**M54 to M6 Link Road**  
**TR010054**  
**Volume 8**

**8.2 DMRB Updates and the Impact on  
the DCO Application**

## M54 to M6 Link Road Development Consent Order 202[ ]

<b>Regulation Number</b>	Regulation 5(2)(a)
<b>Planning Inspectorate Scheme Reference</b>	TR010054
<b>Application Document Reference</b>	8.2
<b>Author</b>	M54 to M6 Link Road Project Team and Highways England

Drawing file: published-documents / TR010054-000745-AS-027 6.2 Environmental Statement Figure 13.1 P04 Low Res.pdf

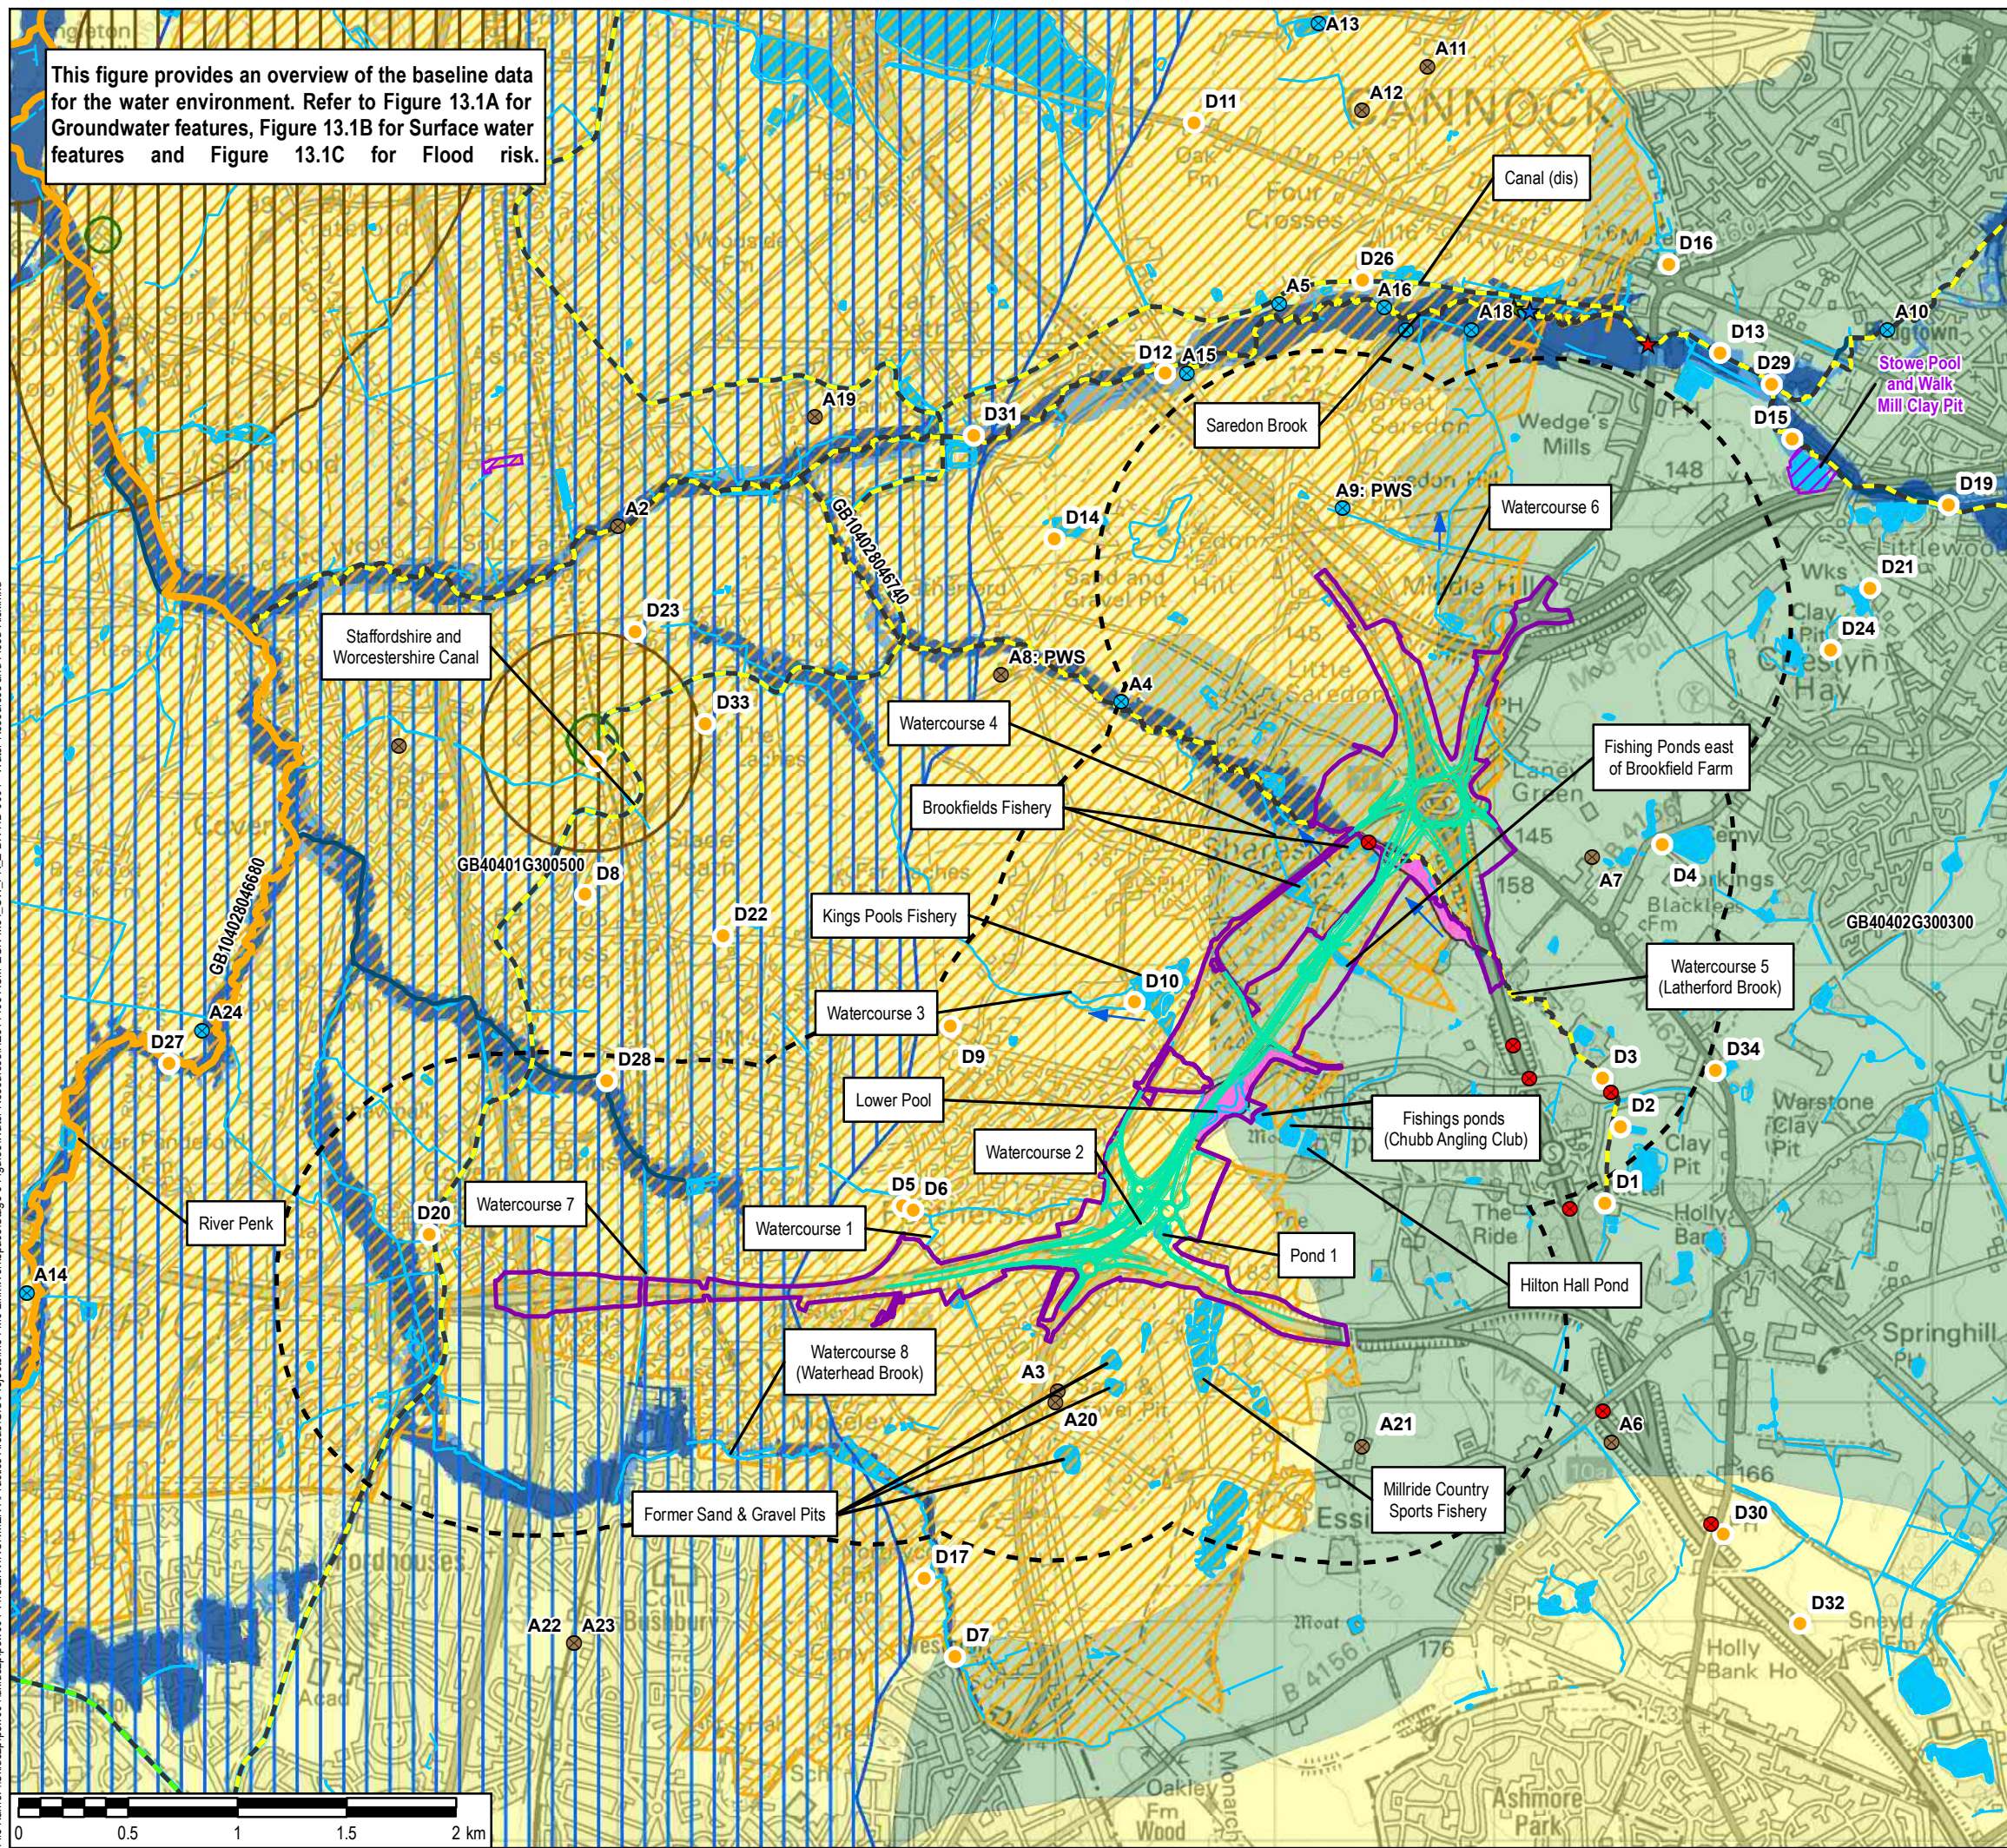
- 1.2.10 At the request of the Inspectorate Figure 13.1 [APP-151/Volume 6.2] has now been split into four figures, Figure 13.1 [AS-027] and Figures 13.1A to C [AS-028 to 030] to better present the information.
